Stage 1 Road Safety Audit Designer's Response

Report Title:	Stage 1 Road Safety Audit Designer's Response – Proposed Site Access, Hemingfield Road, Hemingfield
Date:	21 st August 2024
Document Reference and Revision:	23-160-006.03
Prepared by:	Bryan G Hall Limited
On behalf of:	Barnsley Metropolitan Borough Council (Overseeing Organisation)

This Stage 1 Road Safety Audit Designer's Response has been prepared by Bryan G Hall Limited to address the points raised in the Stage 1 Road Safety Audit of the proposed vehicular access junction with Hemingfield Road, to serve a proposed residential development. The Stage 1 Road Safety Audit was carried out by Bryan G Hall Limited and is dated 15th July 2024 (report reference no. 23-160-005.01).

Drawing No: 23/160/SKH/007 | Revision: E
Job No: 23-160 | Date: 13.10.23

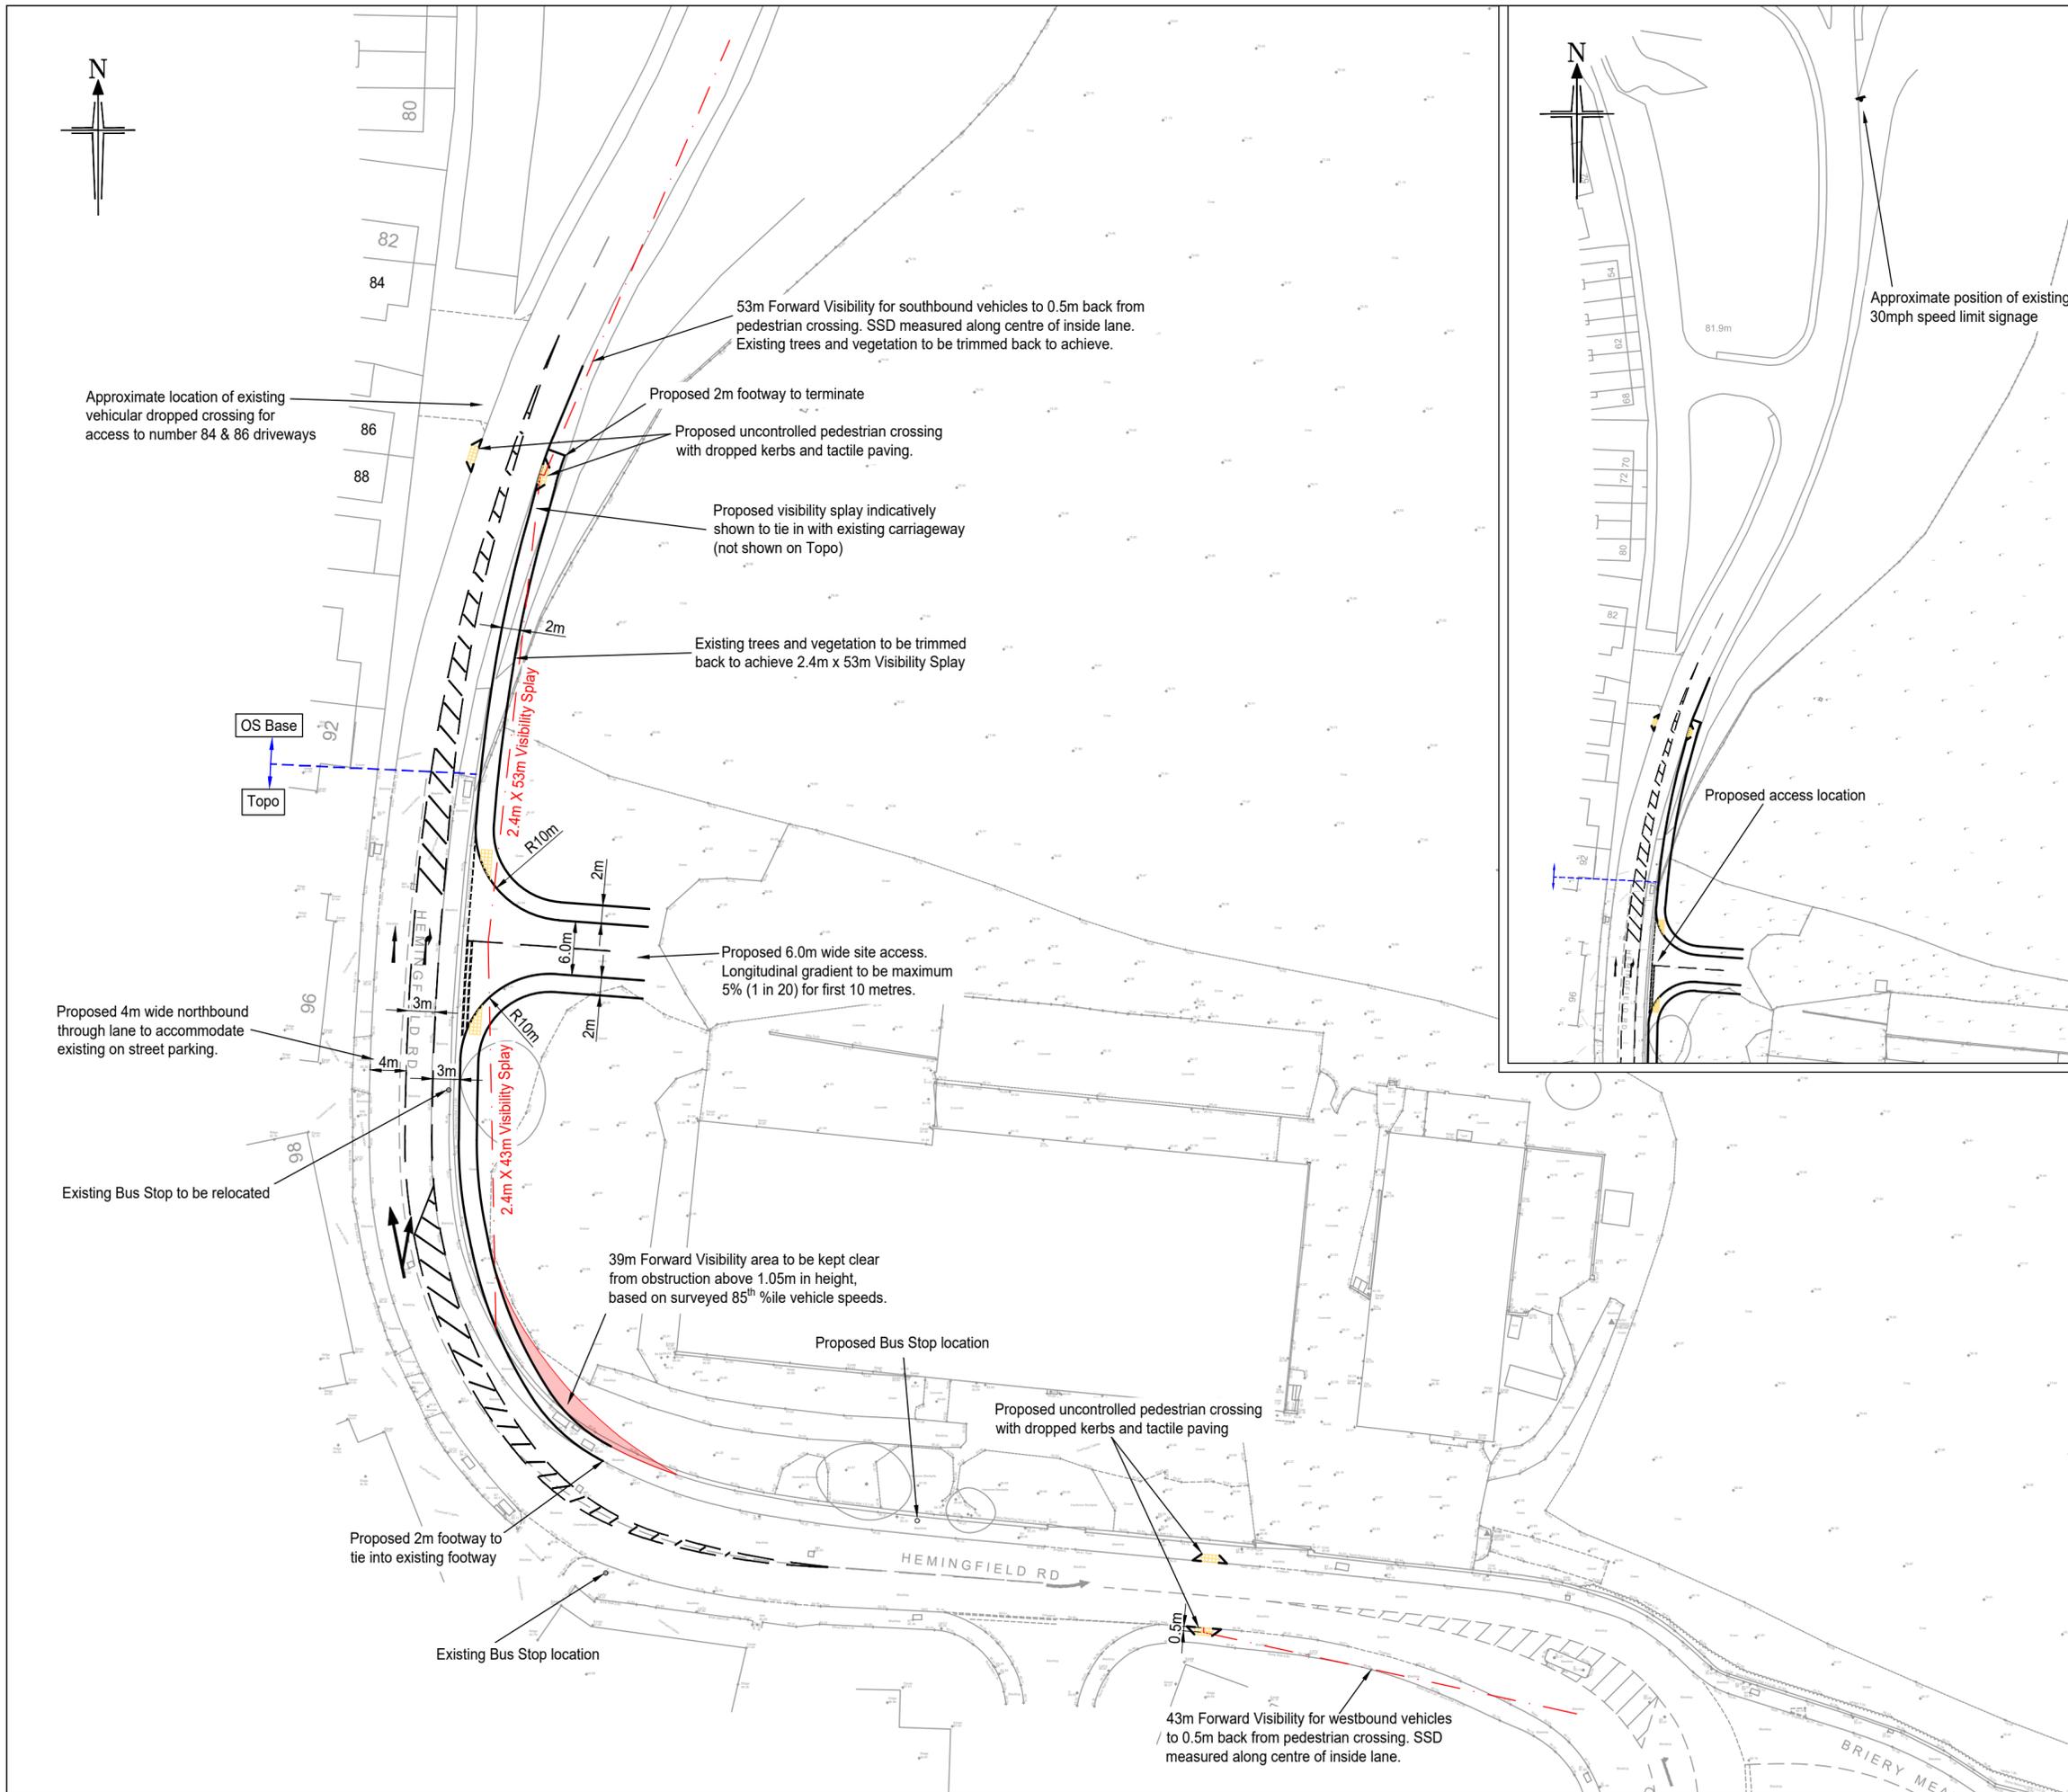
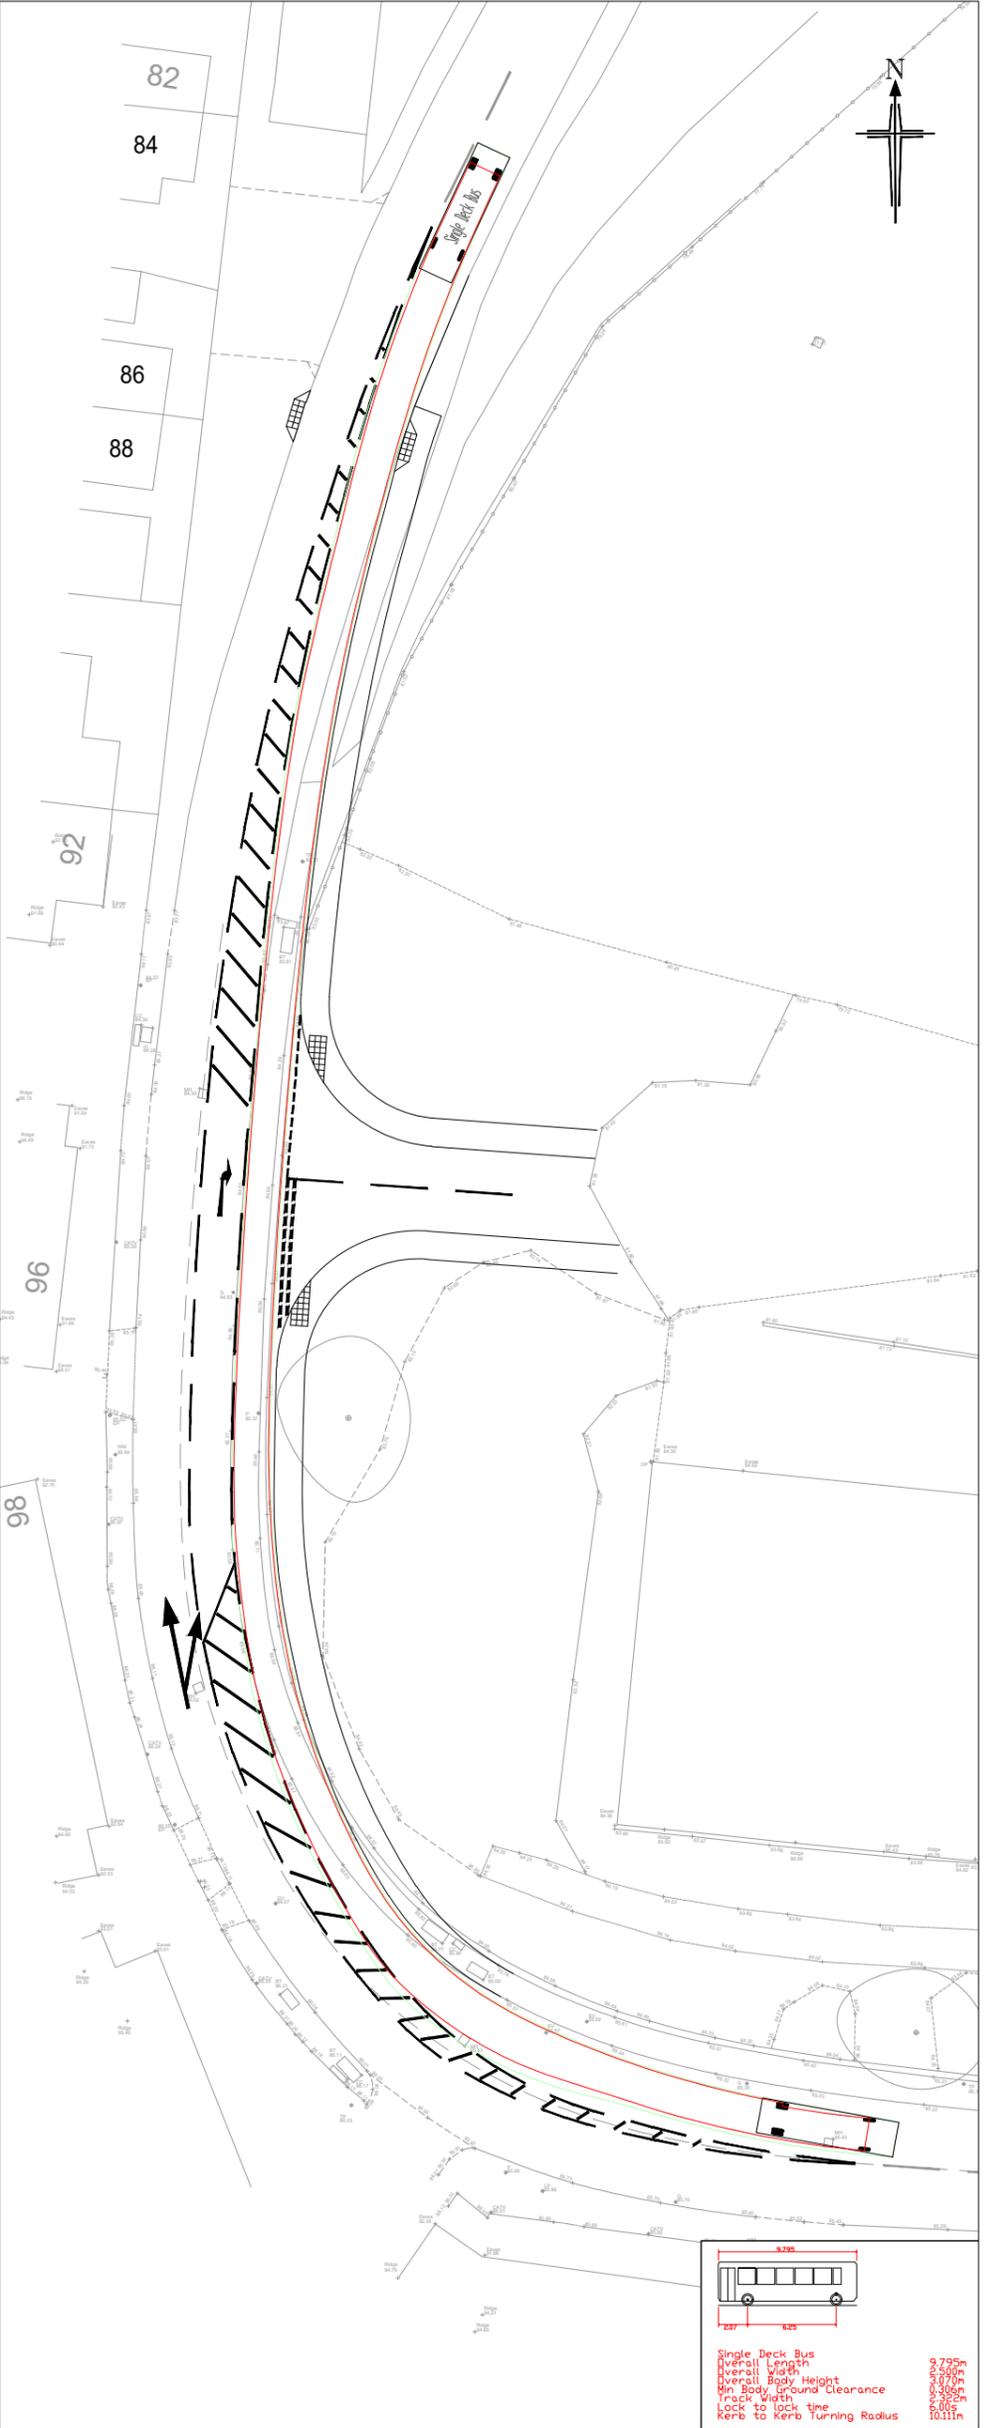
RSA Problem	RSA Recommendation	Design Organisation Response	Overseeing Organisation Response	Agreed RSA Action
Problem A				
Parking on western side of Hemingfield Road opposite the proposed site access.	It is recommended that measures to ensure that parking does not restrict carriageway width opposite the proposed side road are provided.	<p>Paragraph 5.9 of the Transport Assessment (document ref. 23-160-001.03) sets out that a 4 metre wide northbound through lane is proposed to accommodate the existing on street parking on Hemingfield Road in the vicinity of the proposed site access junction. This, alongside the provision of the 3 metre wide right turn ghost island means that traffic can continue to flow while vehicles are waiting to turn right into the site.</p> <p>Should vehicles be parked fully within the carriageway, this would require 2 metres of carriageway width, in line with the guidance in Figure 8.18 of Manual for Streets for parallel parking spaces. When combined with the proposed 3 metre wide right turn ghost island, there would therefore be an available width of around 5 metres for a car waiting to turn right into the site and a northbound car to pass through. It has been observed on site that vehicles currently park partially on the footway, therefore the available width may even be more than 5 metres.</p> <p>Figure 7.1 of Manual for Streets indicates that a minimum carriageway width of 4.1 metres is wide enough for two cars to pass each other, therefore a width of 5 metres is considered to be appropriate to accommodate a car waiting to turn right and a northbound car passing through.</p> <p>Figure 7.1 of Manual for Streets indicates that a minimum carriageway width of 4.8 metres is wide enough for a car and a larger rigid vehicle to pass each other. Therefore it may also be possible for a northbound refuse vehicle or a bus to pass a car waiting to turn right into the site. If not,</p>

Problem C				
Footway provision on Hemingfield Road to the north of the proposed access.	It is recommended that tactile paving and dropped kerbs are provided at a suitable location to the north of the proposed access and that appropriate intervisibility is provided between the crossing location and oncoming vehicles.	<p>The proposed site access drawing has been amended to extend the proposed footway on the eastern side of the carriageway to the north for around 45 metres. An uncontrolled pedestrian crossing point with dropped kerbs and tactile paving is then proposed to be located in the vicinity of numbers 86 and 88 Hemingfield Road, just to the south of the existing vehicular dropped crossing which provides access to the private driveways for number 84 and 86 Hemingfield Road.</p> <p>53 metres forward visibility will be provided for southbound vehicles on Hemingfield Road to see</p>

Problem E				
Proposed bus stop relocation location on Hemingfield Road.	It is recommended that forward visibility between drivers on the southbound carriageway of Hemingfield Road and the relocated bus stop is reviewed and measures are provided to ensure that the visibility envelope remains clear of obstruction.	<p>The exact location of the relocated bus stop is to be agreed with BMBC and the local public transport operators.</p> <p>Table 5.1 of the Transport Assessment shows that the surveyed 85th percentile speeds for eastbound vehicles in the vicinity of the relocated bus stop is 28.3mph, which equates to a 39 metre stopping sight distance. The proposed site access drawing has been amended to show a red hatched area within the site behind the proposed footway on the inside of the bend. The red hatched area will need to be kept clear from any obstruction above 1.05m in height, in order to provide 39 metres forward visibility around the bend and towards the relocated bus stop.</p>

RSA Problem	RSA Recommendation	Design Organisation Response	Overseeing Organisation Response	Agreed RSA Action
		<p>then the northbound vehicle would simply need to wait briefly for the right turning car to clear. The modelling of the proposed site access junction shows that there would be minimal delays to vehicles turning right into the site of around 6/7 seconds and that queuing of more than 1 vehicle is not likely to occur, therefore this is not considered to be an issue.</p> <p>Furthermore, at present, it is apparent that vehicles may have to encroach into the opposing carriageway to pass the parked vehicles. Therefore, it is considered that the proposed site access arrangement represents an improvement over the existing situation.</p>		
Problem B				
Hemingfield Road southbound approach to the proposed site access.	Provide sufficient stopping sight distance on approach to the proposed new junction from the north.	<p>In response to Problem C, a footway is now proposed to the north of the access, which will necessitate the removal of some vegetation in this area. Any remaining vegetation within the adopted highway is to be trimmed back as necessary to achieve the 2.4 metres x 53 metres visibility splay to the north.</p> <p>A note has been added to the proposed site access drawing to clarify this.</p>

RSA Problem	RSA Recommendation	Design Organisation Response	Overseeing Organisation Response	Agreed RSA Action
		<p>pedestrians on the eastern side of the crossing at a point 0.5 metres back from the dropped kerb. The 53 metres stopping sight distance has been measured along the centre of the southbound carriageway. The existing trees and vegetation will be trimmed back as necessary to achieve this forward visibility.</p> <p>On the western side of the carriageway, the proposed crossing is located where existing dwellings have private driveways and some additional block paved space in front of the properties to park off the carriageway. Therefore crossing pedestrians are very unlikely to be masked by vehicles parked on Hemingfield Road.</p>		
Problem D				
Site access pedestrian crossing facilities	It is recommended that tactile paving and dropped kerbs are provided at a suitable location on the desire line across the minor arm of the proposed junction.	An uncontrolled pedestrian crossing with dropped kerbs and tactile paving will be provide at the proposed site access as suggested. The proposed site access has been amended to show this.
